PLANNING CONSULTATION RESPONSE

Application No	2025/0775
Proposal	Development of 4 residential dwellings, landscaping and associated infrastructure
Address	Land east of Bank View, Bower Hill Road, Oxspring, Sheffield, S36 8YA
Date of Consultation Reply	09/12/2025
Consultee	Katie Lawrence, Planning Ecologist

Figure 1: UK HABS Habitat Classification Map Baseline - measured

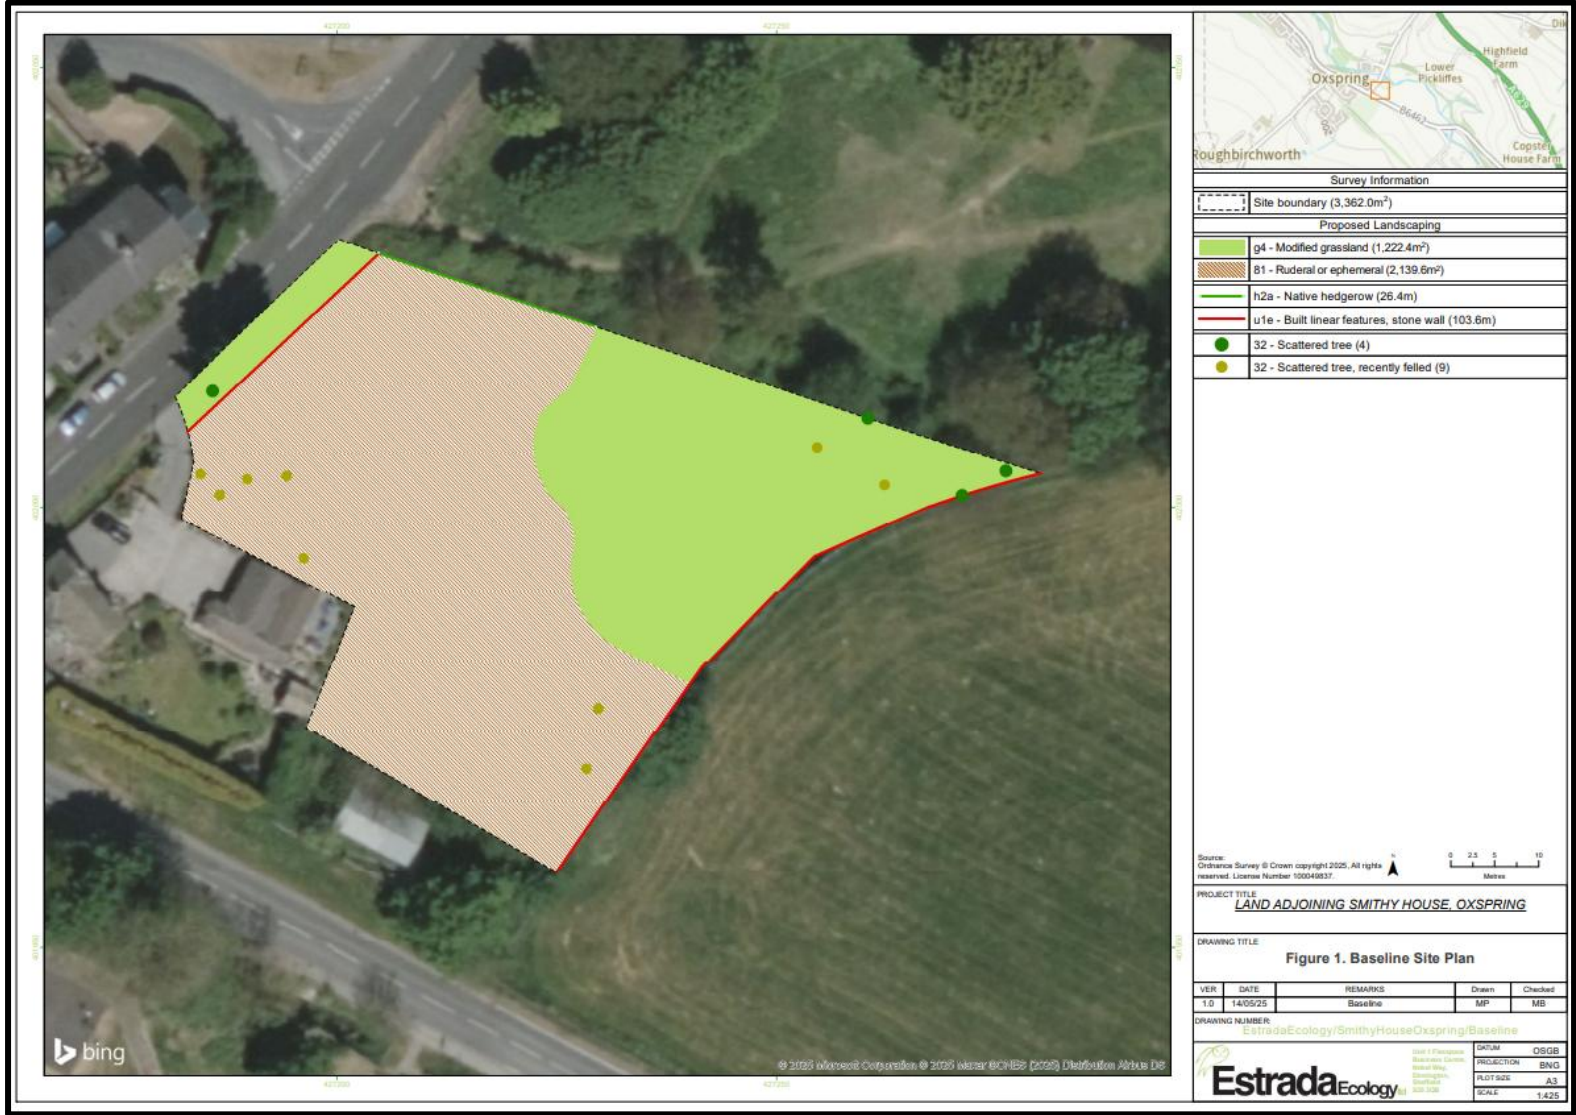
- An email which accompanied the updated metric and report sets out that justification is given for the condition assigned to the tall ruderal habitat within the metric. When referring to the metric the user comments simply say that condition criterion A and B have been failed. As set out in my previous response, due to clearance works being undertaken prior to the baseline habitat survey being carried out, a precautionary approach should be adopted when assigning condition and I don't believe it can be confidently concluded that these criteria would have been failed.
